# CITY OF ALBUQUERQUE

July 29, 2014

**Re: Sevano Place Subdivision Drainage report and Grading Plan  
Drainage Report, Grading and Drainage Plan  
Engineer's Stamp Date 7-25-14 (C18D075)**

GRADING & DRAINAGE PLAN

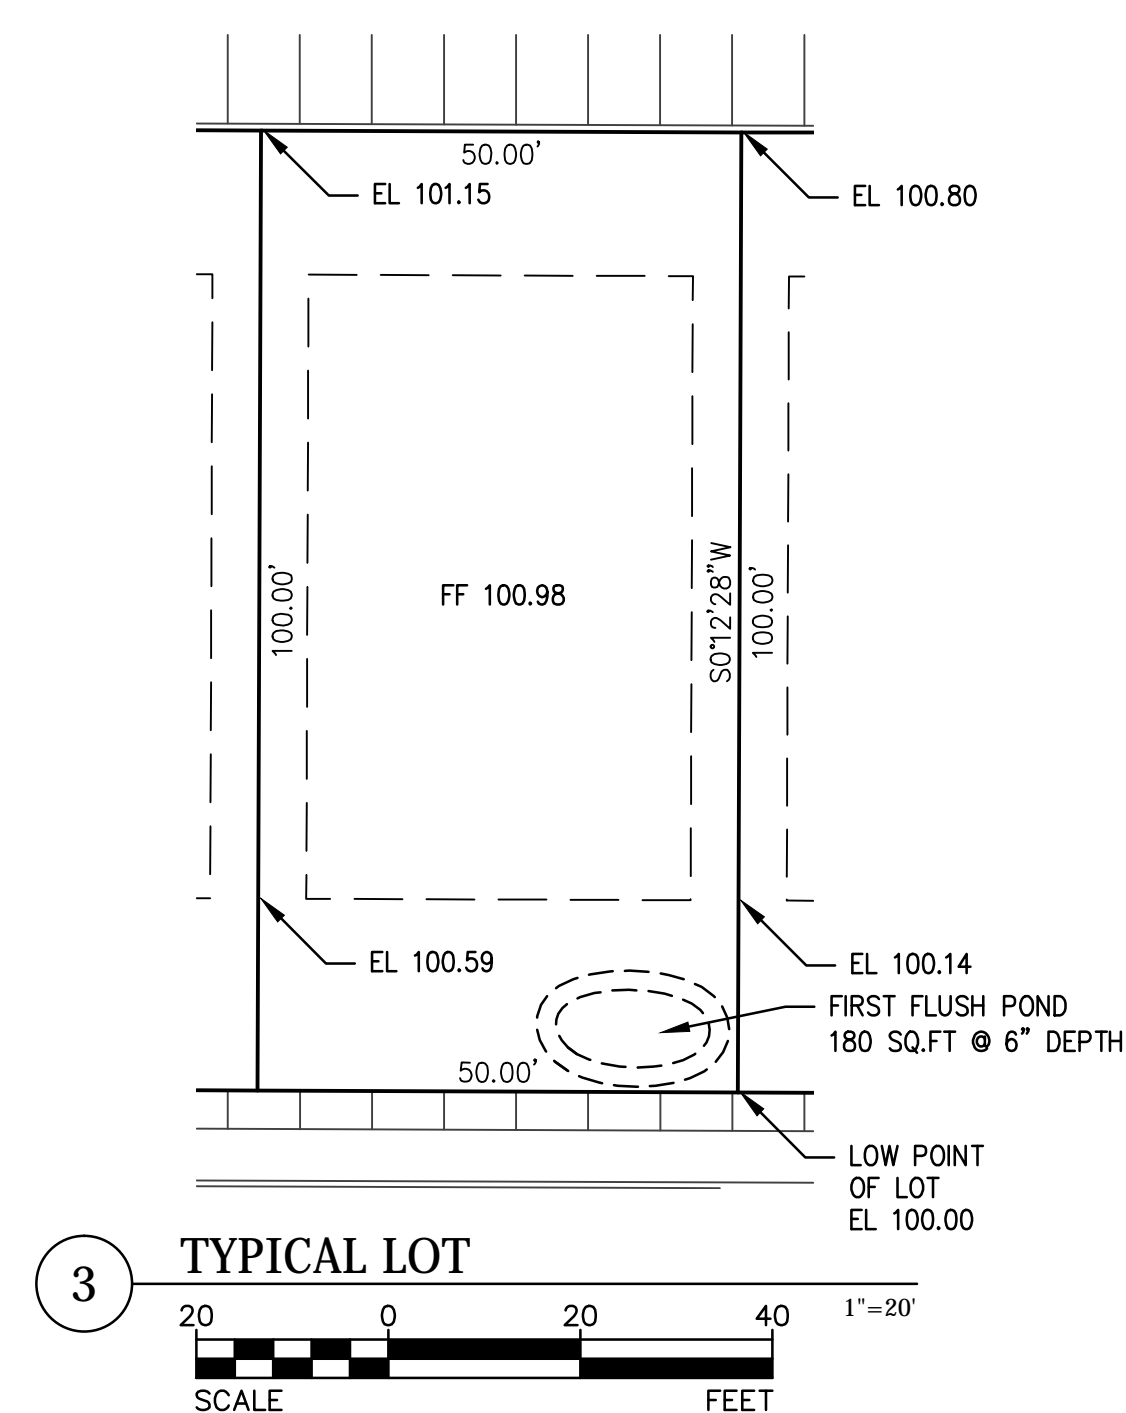
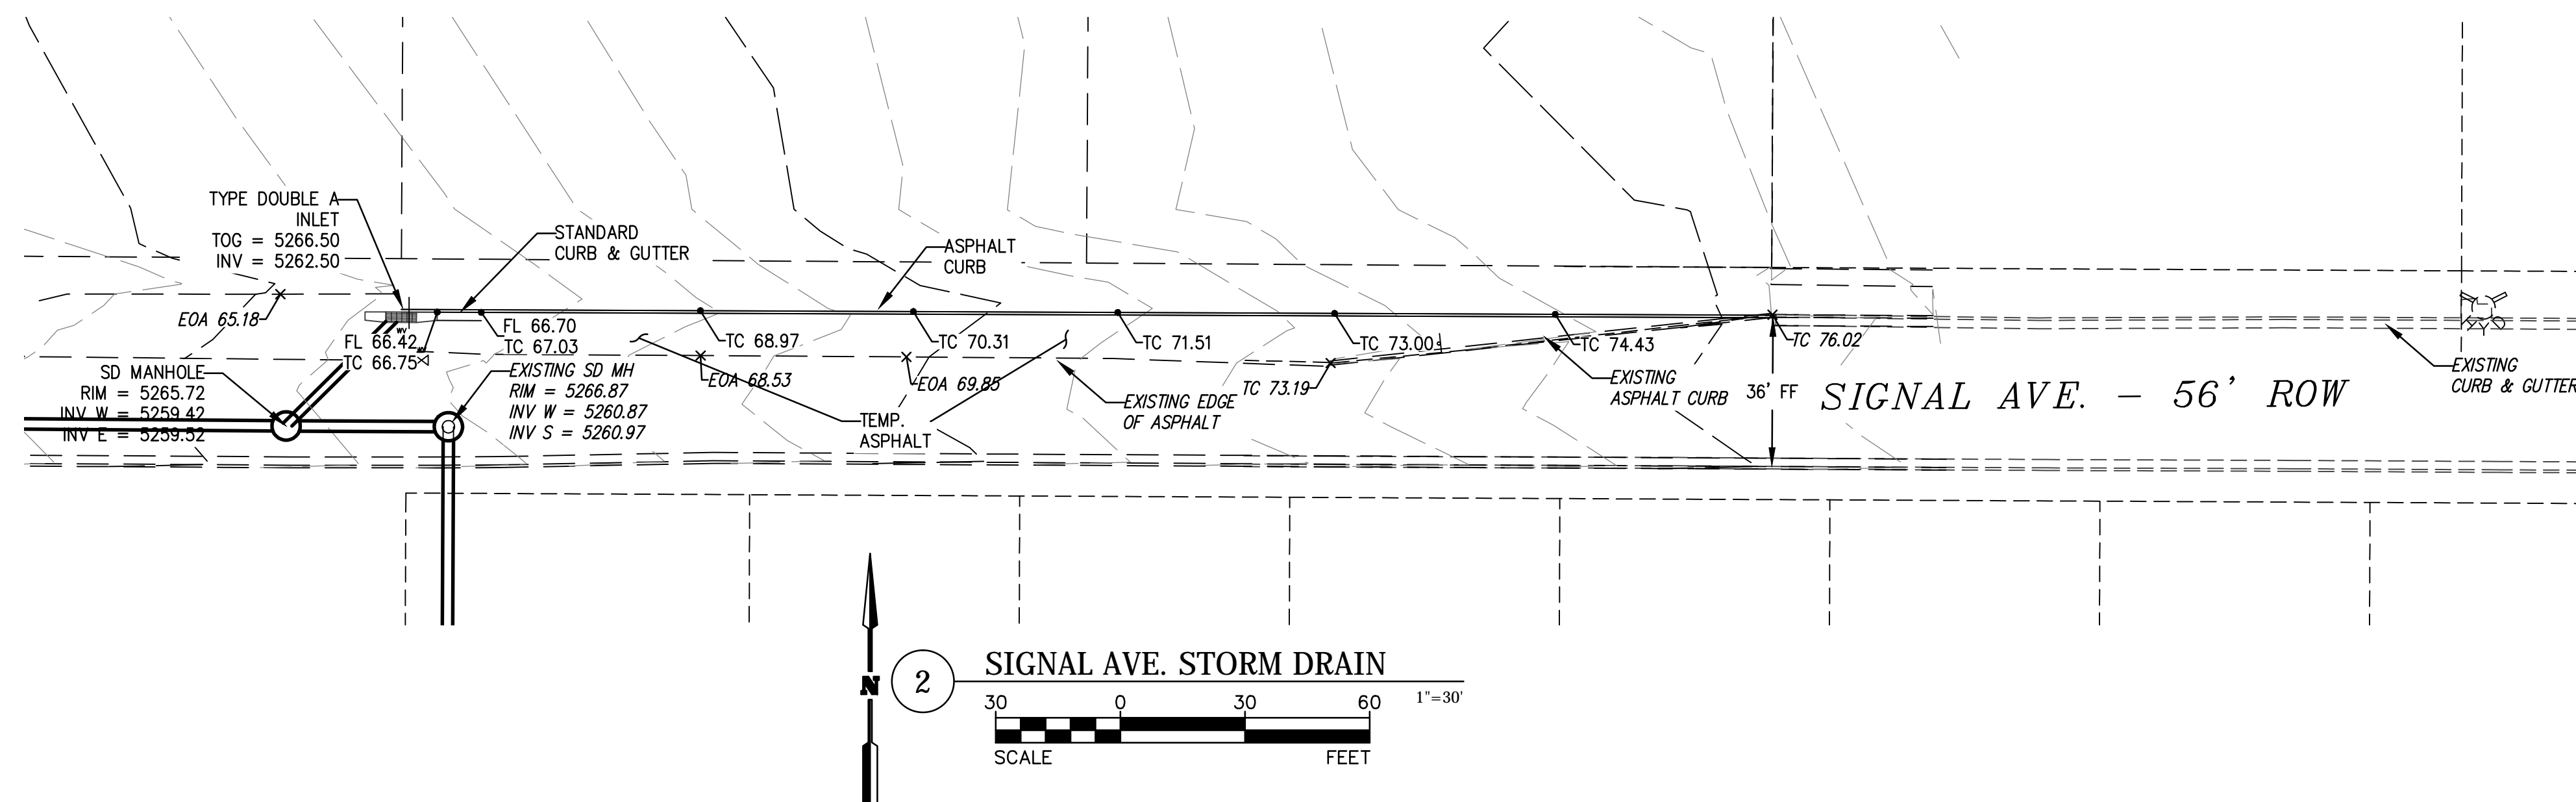
- a. Hydrology did not see calculations in the report for the sidewalk culverts; the summary table on page 9 should be supported by calculation in the appendix. Plans should indicate that there are (3) 2' culverts.
- b. Hydrology did not see calculations in the report for the Sag A Inlets; the summary table on page 9 should be supported by calculation in the appendix.
- c. Plans show an opening in the wall, but there are no details to indicate whether it is an overturned block or a discontinuous wall. There is no invert elev. indicated or dimensions. Call out as an emergency spillway to show the intent. The wall opening further away from the culverts seems too far to catch overflow unless the invert is low enough. Provide calculations showing capacity of the openings.
